Planning Application No: 3/2026/0583

Proposal: Proposed two storey extension.

Location: Higher Elker Lodge Whalley Road Billington BB7 9HY

Tahira Akhtar BA (Hons)
Technician
Highway Development Control
Highways & Transport
Lancashire County Council

Drawing Title:
Proposed Ground Floor Plan

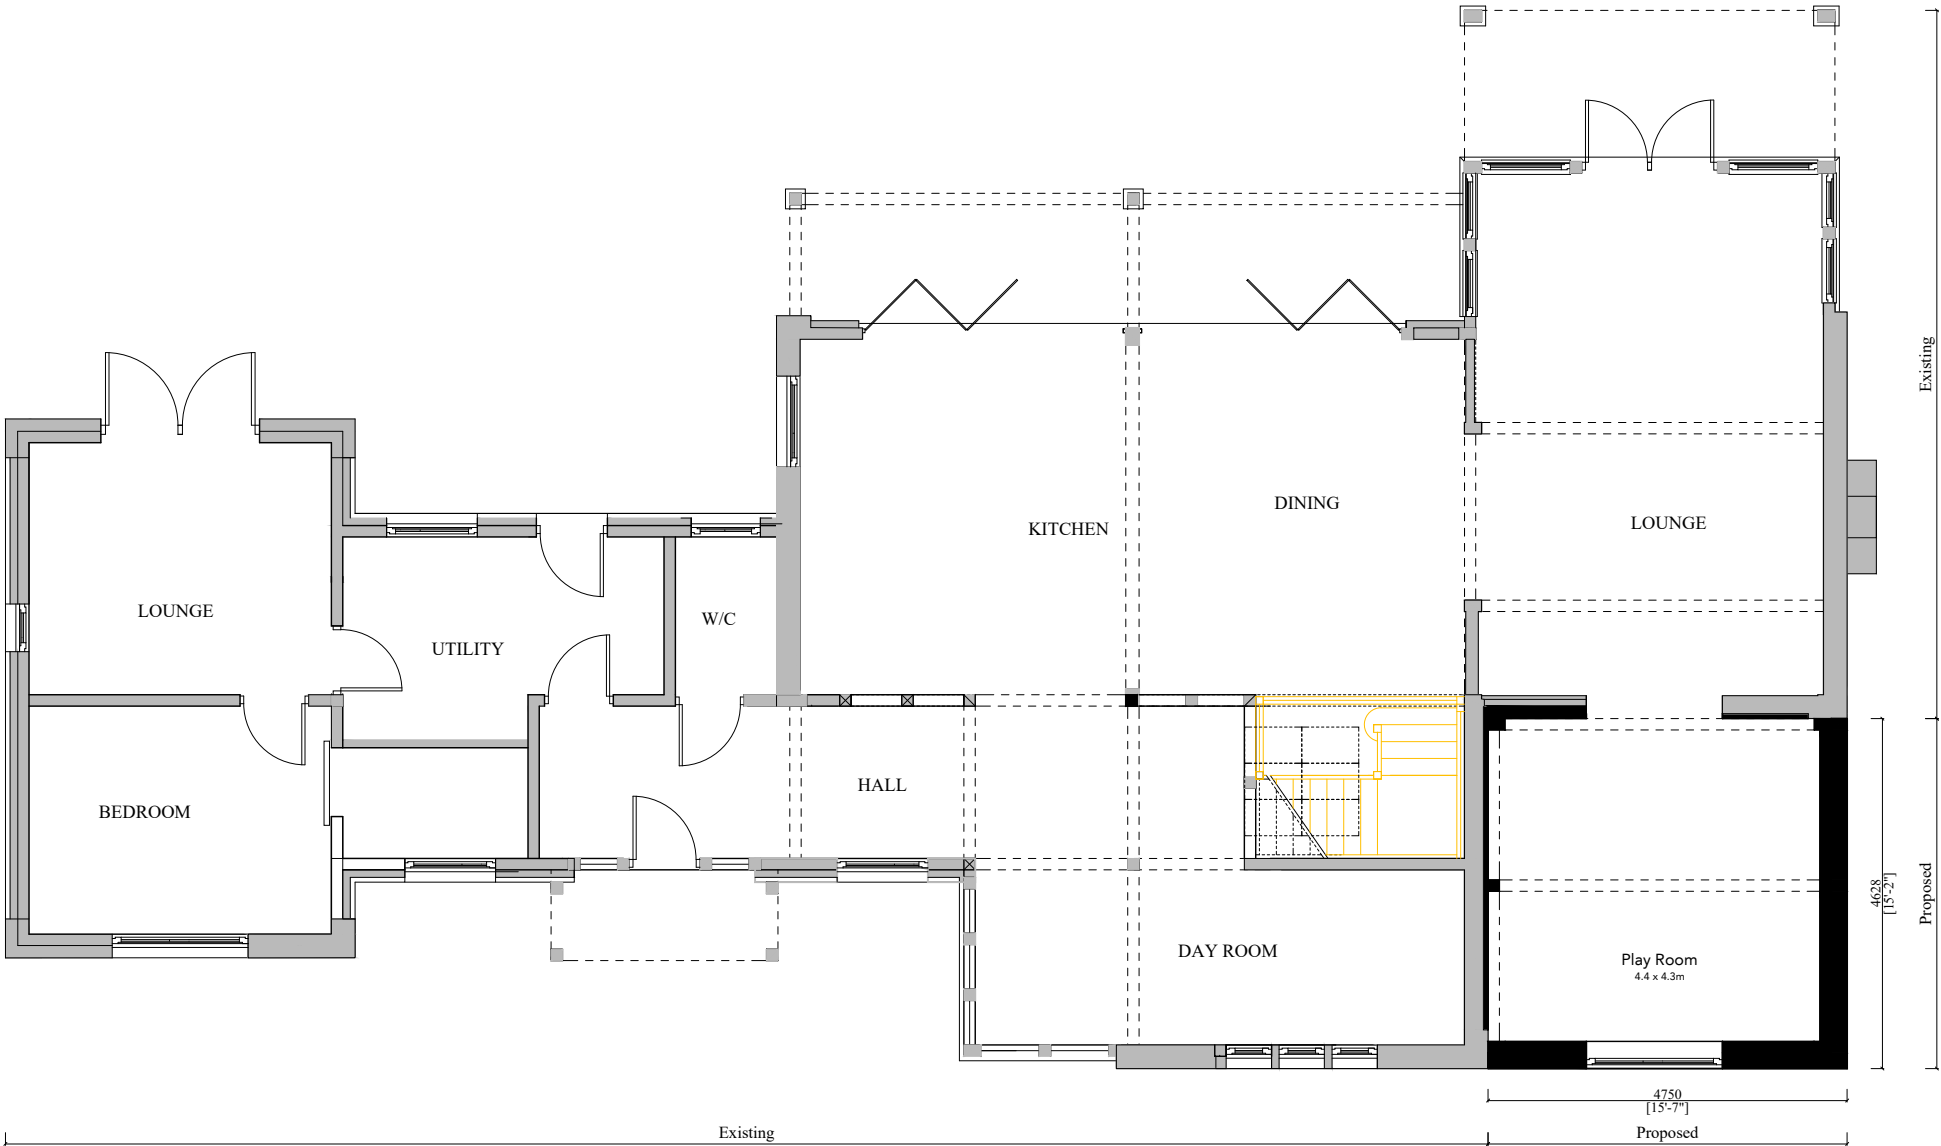
The proposal creates an increase in bedroom numbers from the existing 2 to 3. There is no change to parking standard requirements with this proposal. The required 2 parking spaces can be achieved on the drive.
